From  
The Member-Secretary,  
Chennai Metropolitan  
Development Authority,  
No.1, Gandhi Irwin Road,  
Egmore,  
Chennai - 600 008.

Letter No. A1/15894/2001

Sub: CMDA - Planning Permission - Construction of Ground + 1  
with Stilt Floor of Residential/~~Commercial~~ Building at  
Plot No.55/8 in S.No.158/1B1C part of  
Thiruvanniyur Village.

STILT CUM GROUND FLOOR PLAN

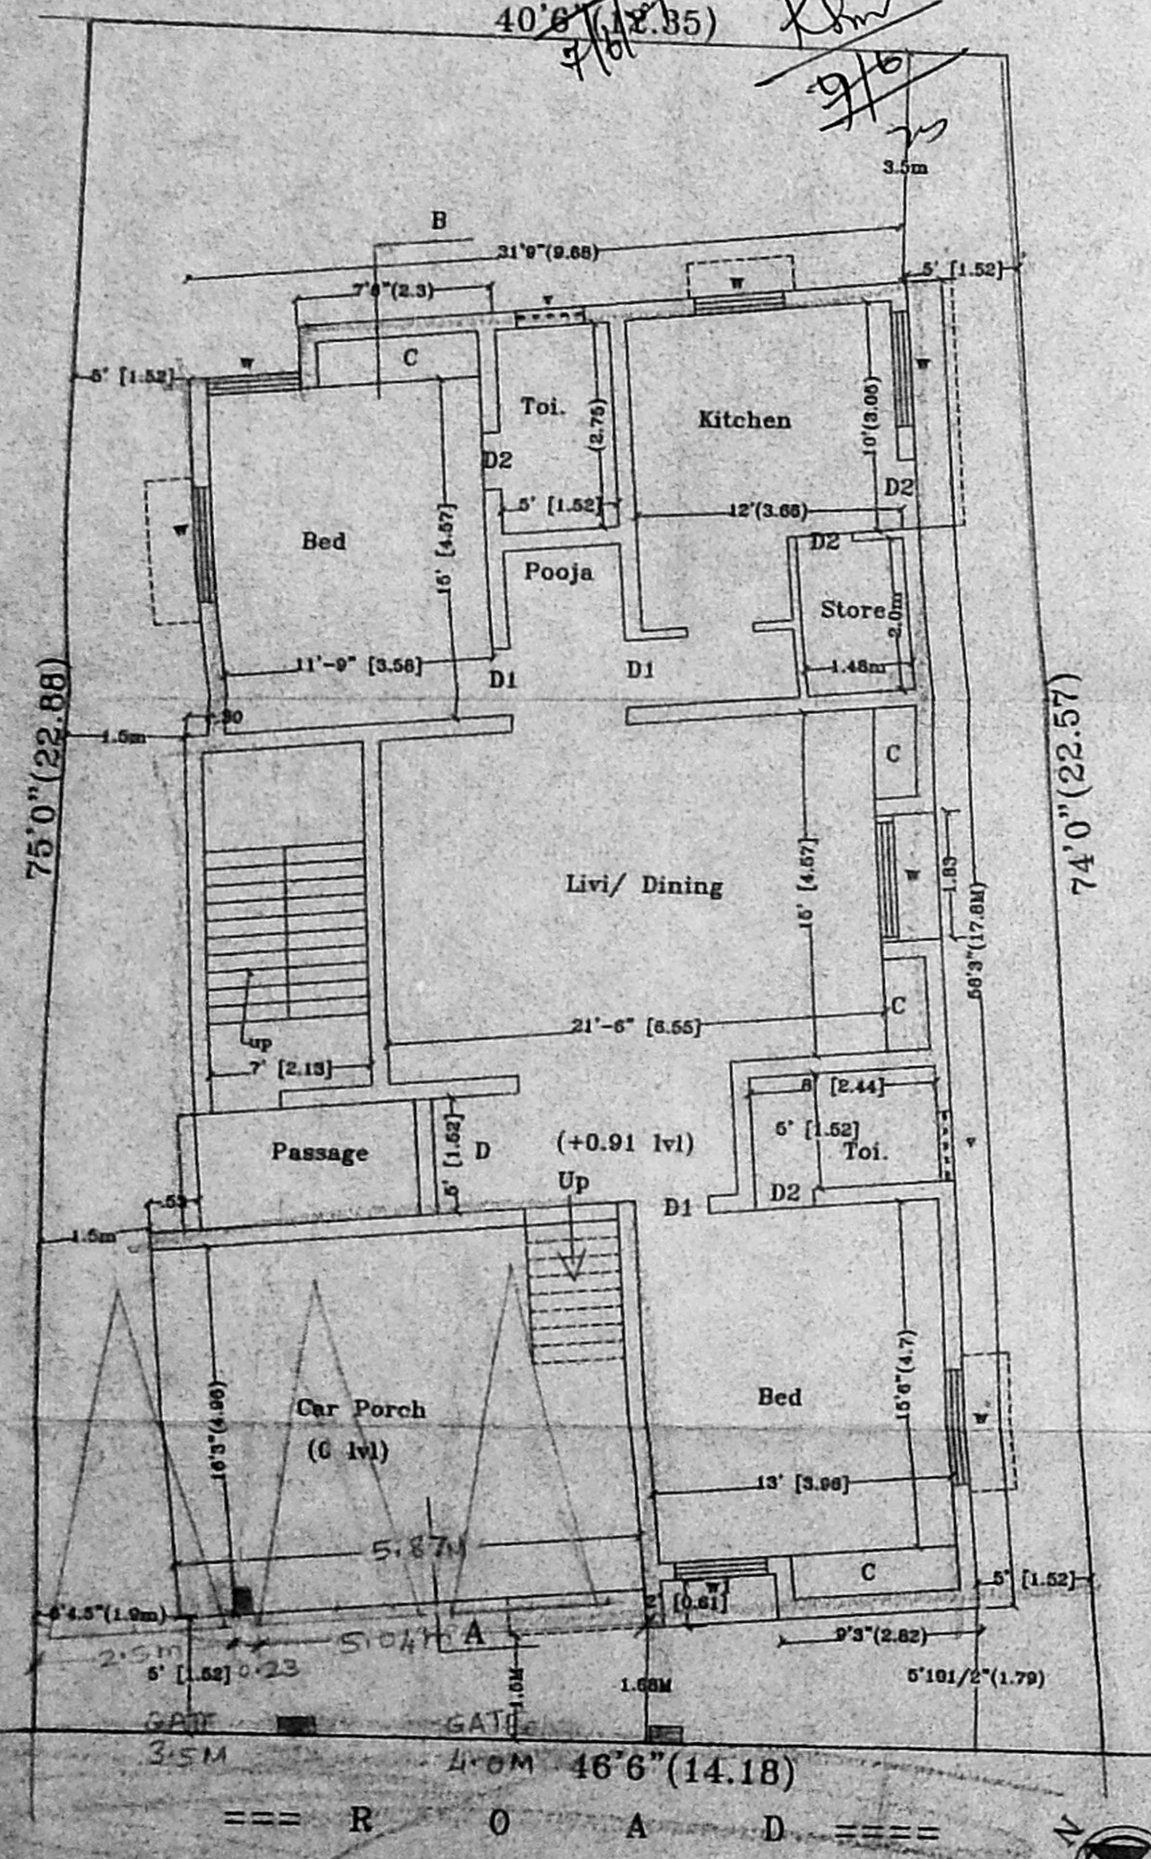
**xx(b) Five copies of Revised Plan showing one more car park ~~lot~~ by shifting the column and arranging the column with necessary intervals without affecting the car park first provision.**
